**M1 Pacific Motorway extension to Raymond Terrace (SSI 7319)
Advice on the Environmental Impact Statement (EIS)**

Thank you for the request for advice from Public Authority Consultation (PAE-24749572), requesting the review by the NSW Environment Protection Authority (EPA) of the Environmental Impact Statement (EIS) for the proposed M1 Pacific Motorway extension to Raymond Terrace (Application SSI-7319).

ATTACHMENT A: EPA COMMENT ON EIS FOR M1 PACIFIC MOTORWAY EXTENSION TO RAYMOND TERRACE (SSI 7319)

Location: L06 - 61 Redbill Drive, Woodberry

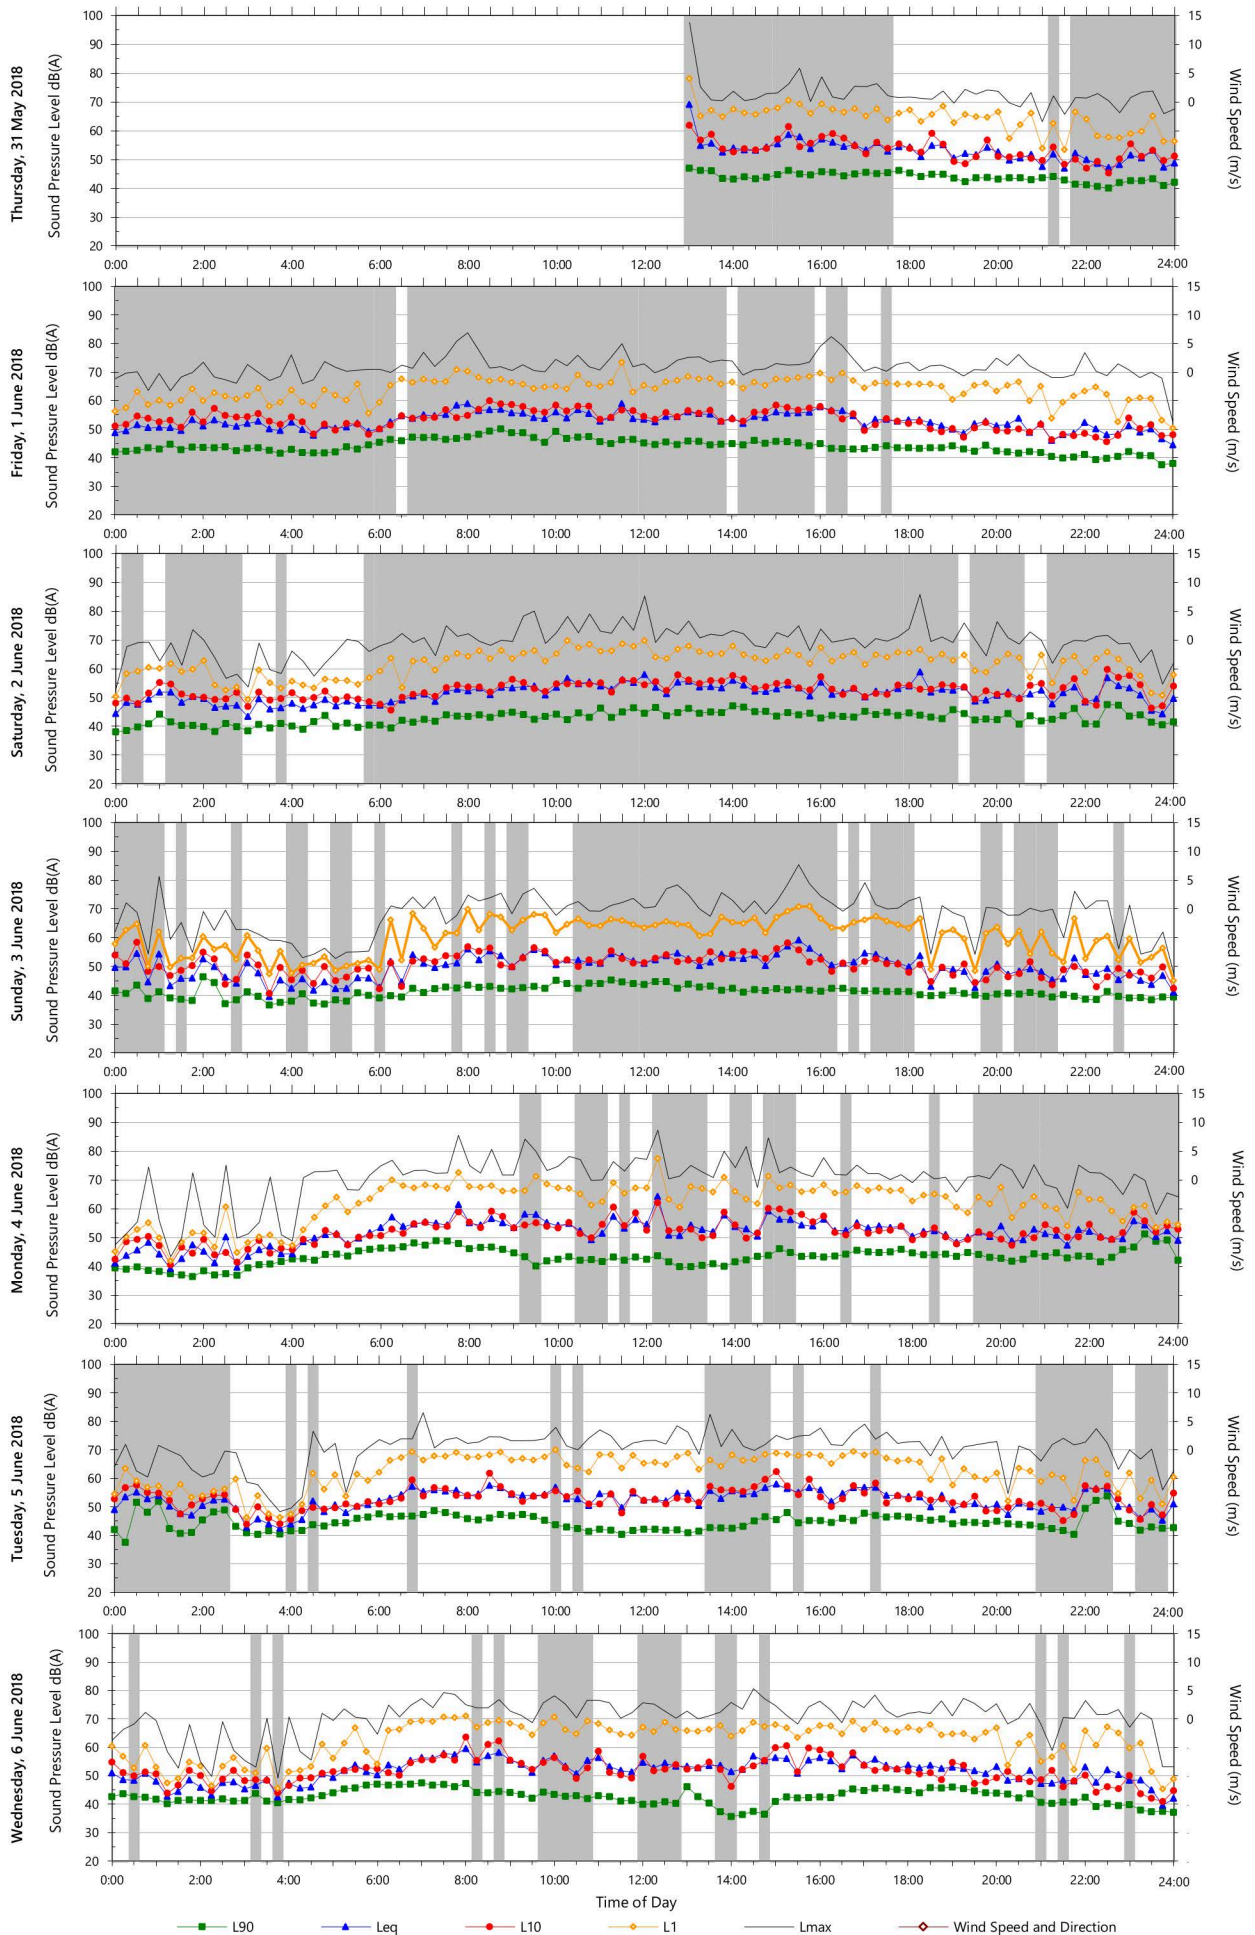
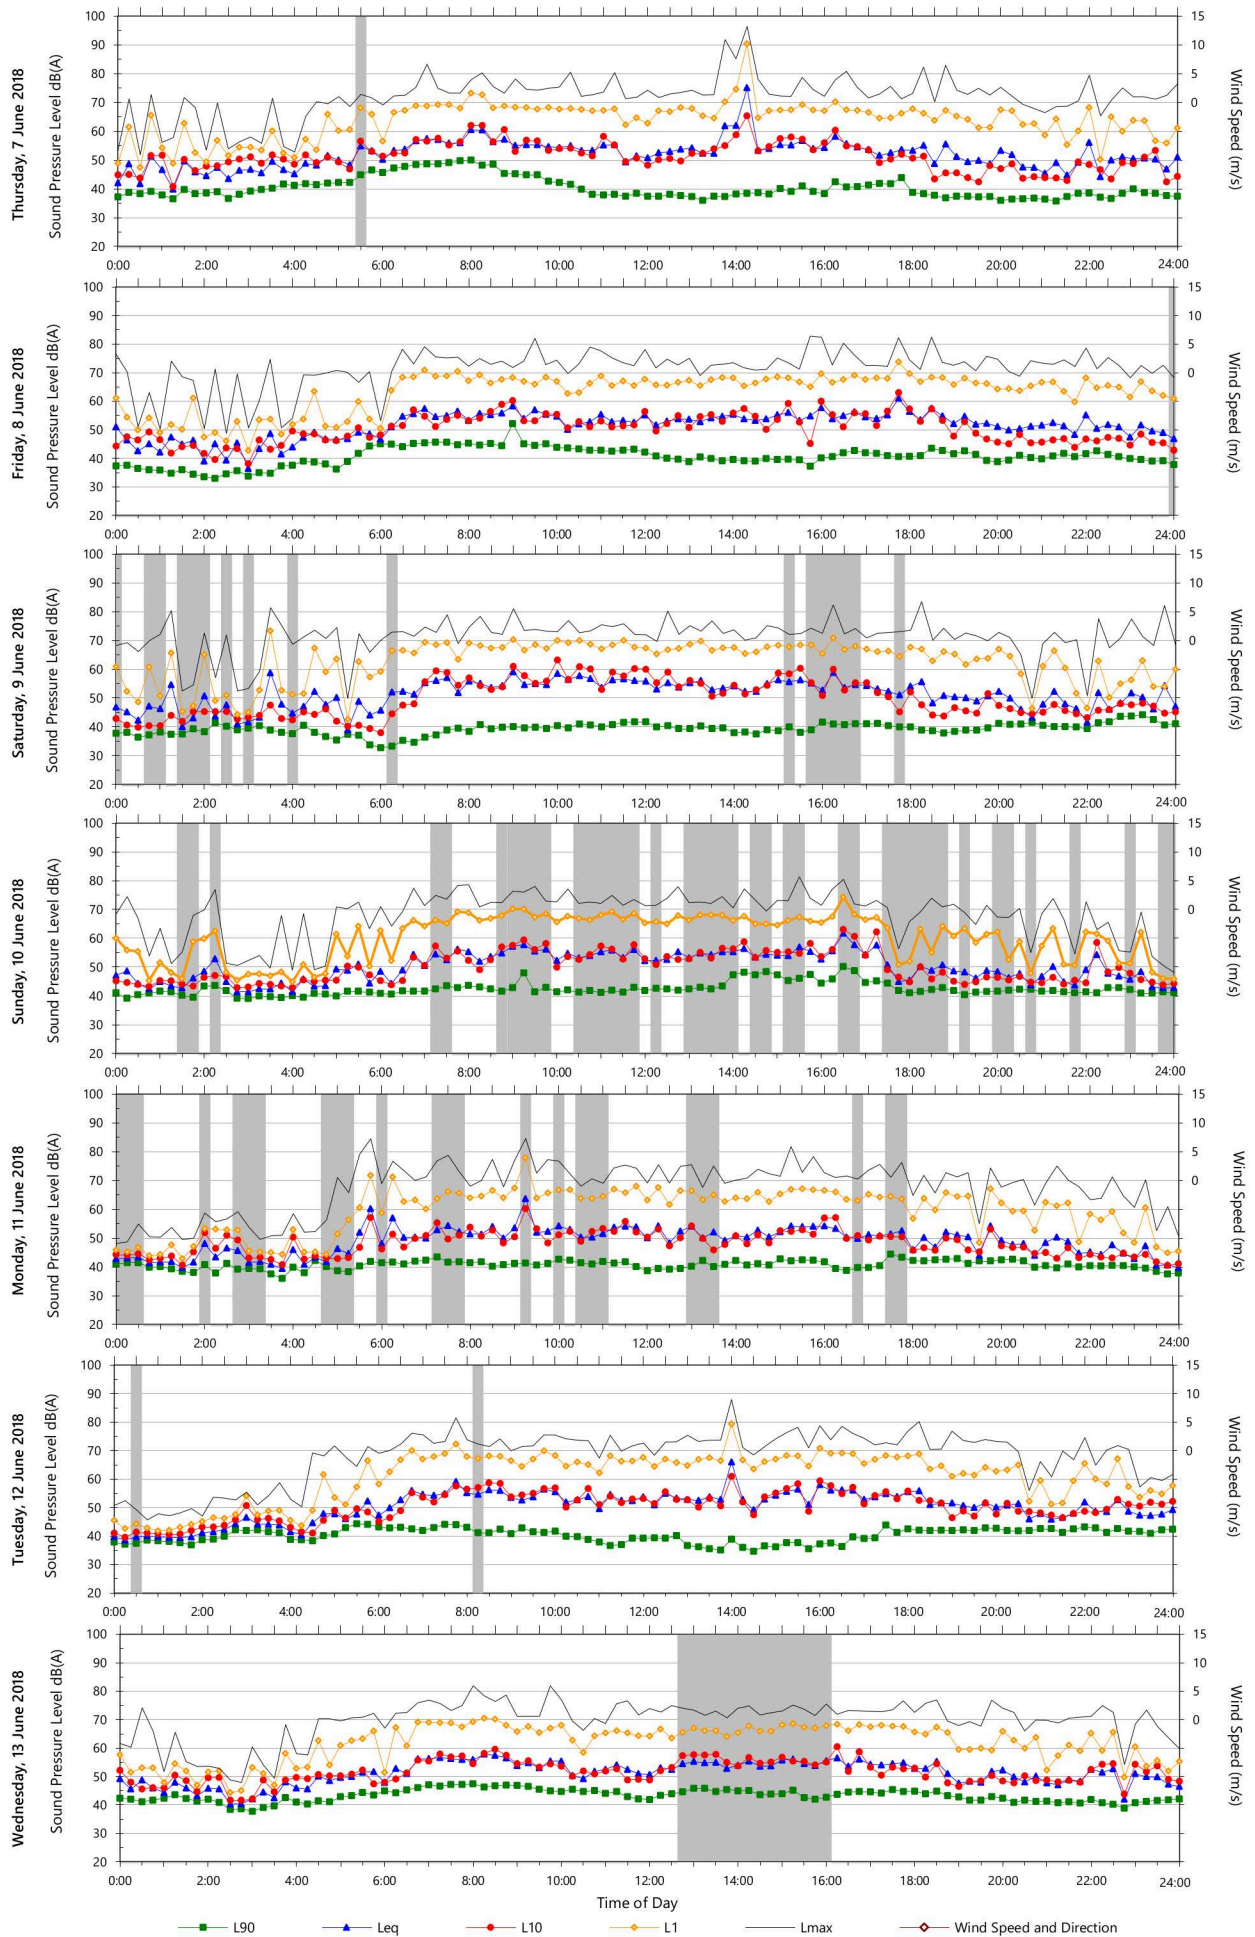
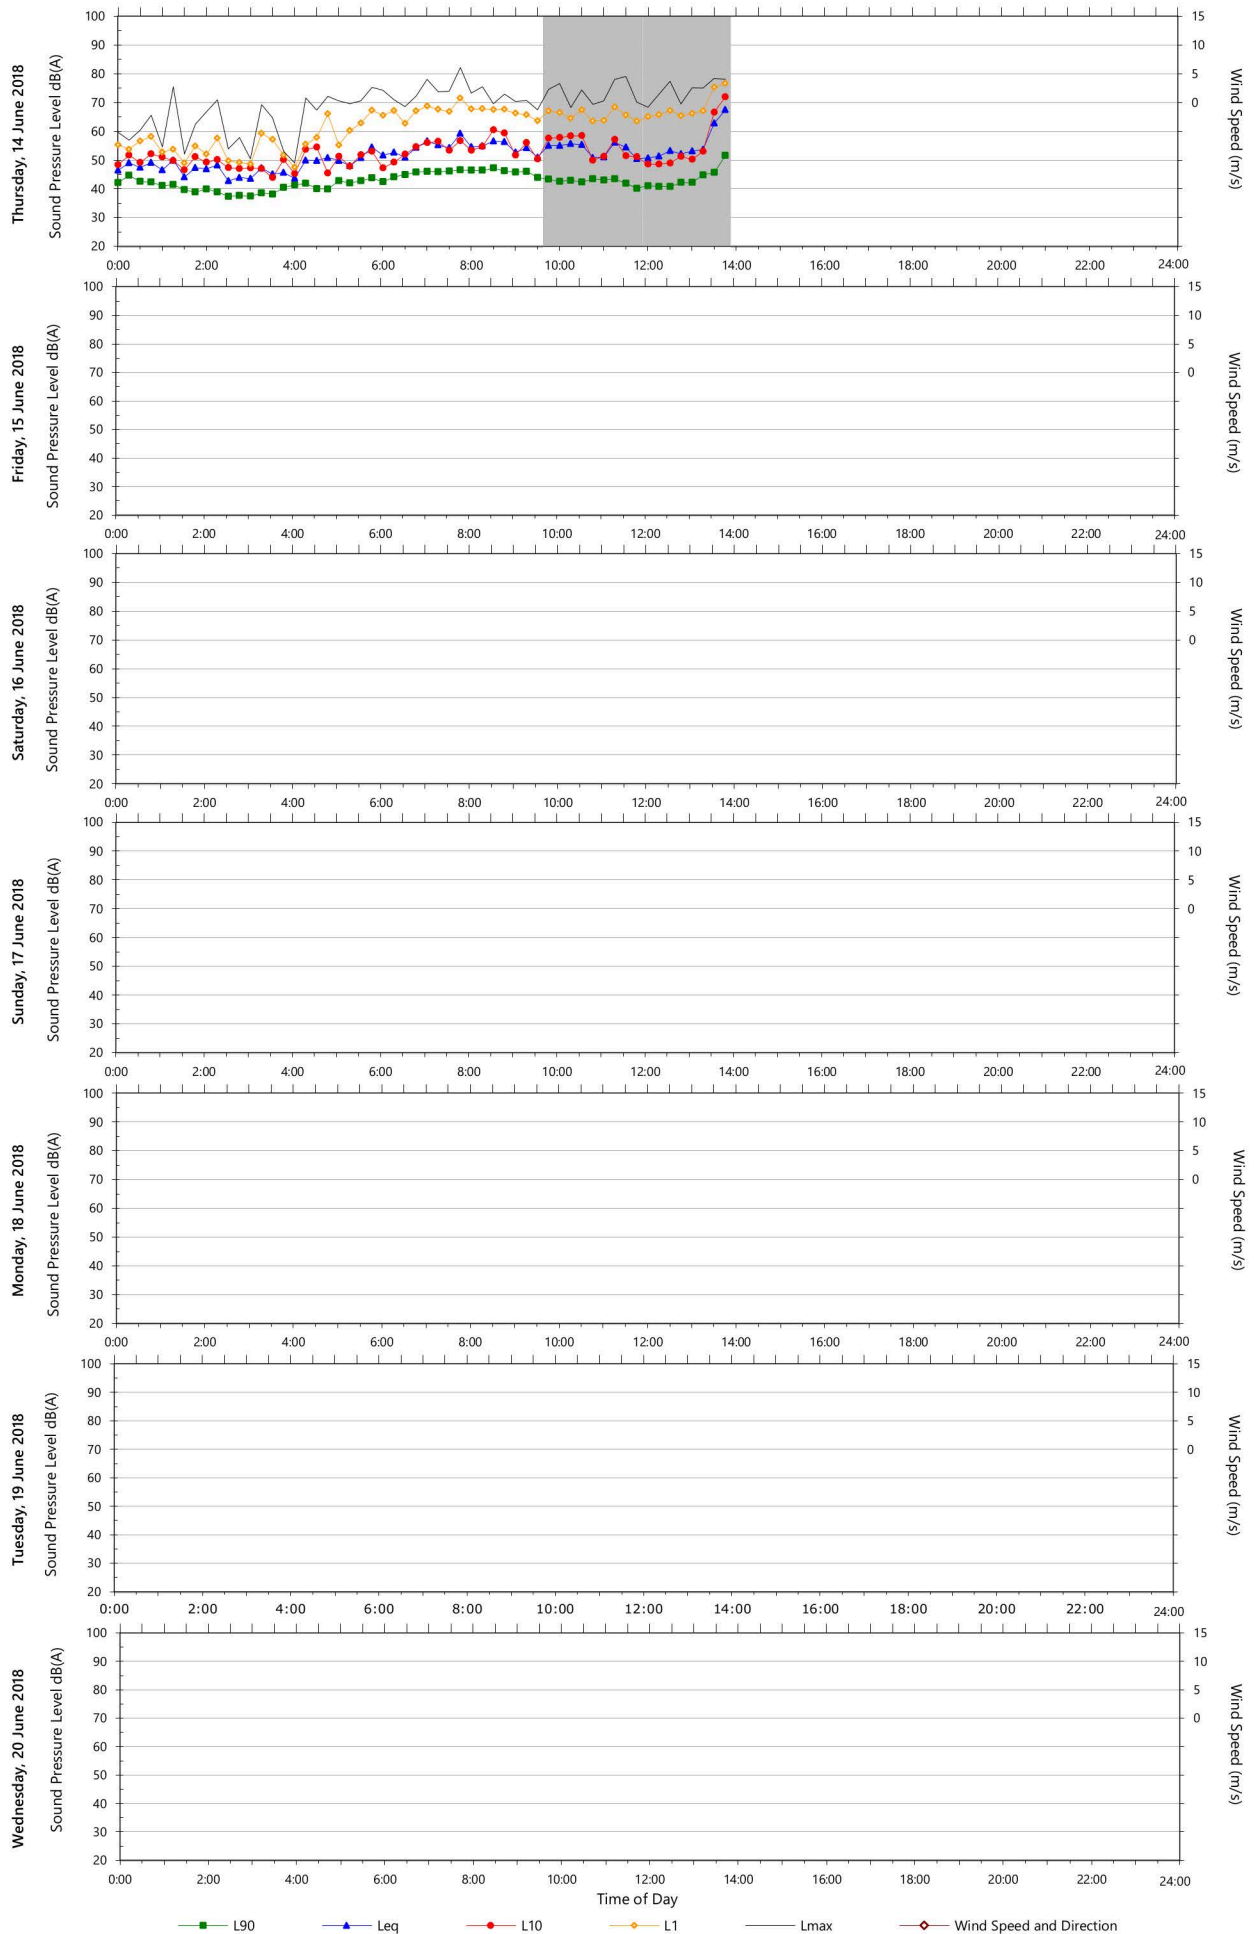
A review of the noise monitoring graphs in NIA Appendix B.2 indicates that further justification for the adequacy of noise monitoring presented or additional information is required.

A significant amount of data appears to have been excluded due to either inclement weather or extraneous noise. The EPA is concerned that the extent of data excluded means that it may not be representative of long term background noise levels, and therefore its suitability to be used to establish reliable noise management levels could be called into question.

Locations L01 to L014 (inclusive) appear to have no more than 5 and in some cases less than 3 valid periods out of the total monitoring duration. Locations L15 to L20 appear to be less affected, however there it is still not clear if sufficient valid data has been presented.

Fact Sheets A and B in the Noise Policy for Industry (NPfI) set out the EPA's requirements for establishing background noise levels. Due to the amount of data excluded, it is currently not clear if these requirements have been satisfied nor if sufficient valid data has been presented in order to establish representative background noise levels.

Noise monitoring was also conducted in 2016 for the purposes of measuring road traffic noise. Due to the amount of data excluded at Locations L13 to L20, further justification is needed that the remaining data, after invalid samples were excluded, provides sufficient amount of data to enable a representative calculation of the traffic noise descriptors.

The proponent reviews the noise monitoring data in the NIA in the context of the monitoring requirements set out in the NPfI and for each location and either:

- Provide a justification and demonstrate that the requirements of the NPfl have been fulfilled; or
- Provide additional data that fulfills the monitoring requirements in the NPfl.

The EPA also recommends that the proponent either:

- Provides justification and demonstrate that the data presented for road traffic noise descriptors is sufficient to be representative; or
- Provides additional valid data.
